**Site 53, 2 Fig Tree Drive, Sydney Olympic Park
Landscape Response to SOPA Review**

SSD 15_7033

Further to our Landscape DA drawings, we refer to SOPA's review and comments relating to landscape architectural components of the proposed development at Site 54, 2 Fig Tree Drive, and provide the following response.

APPENDIX A.
Tree Protection Zones (TPZ) Associated with Trees 1 & 3 at the retail forecourt.

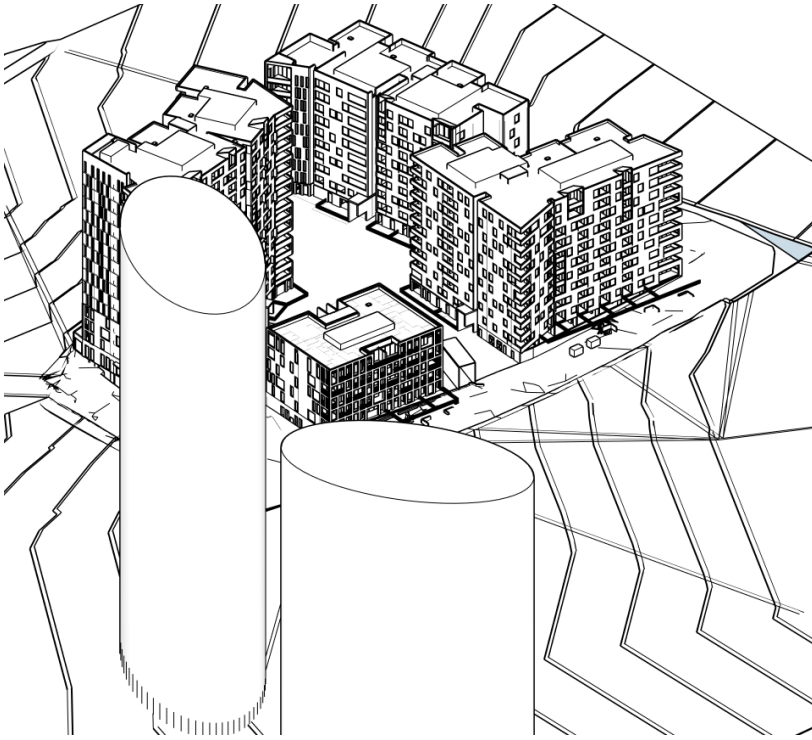
We understand SOPA's recommendation to provide wider paths to connect the retail precinct, and acknowledge that the path up to Fig Tree Drive would provide greater connectivity if widened. However, there are extensive Tree Protection Zones associated with the protection and retention of 2 existing Fig Trees, as documented in the Arborist Report, prepared by Arboreport, which greatly limit the extent of excavation, hardstand and paths. (Refer to Appendix A. for extent of TPZs)

Following further review and consultation with the arborist, Arboreport has advised any increase of forecourt area, paths or addition of deck treatment within the TPZ will significantly compromise the survival of the trees and is not supported. There are significant buttress roots within the area SOPA has proposed decking, furthermore the structure and excavation required for deck footings will greatly impact the trees root system through excavation and compaction. For these reasons, we advise that SOPA's recommendations cannot be accommodated without compromise to the trees health.

We believe that within the constraints, the current design addresses and satisfies SOPA's ambition for the retail forecourt while adhering to strict Tree Protection Controls.
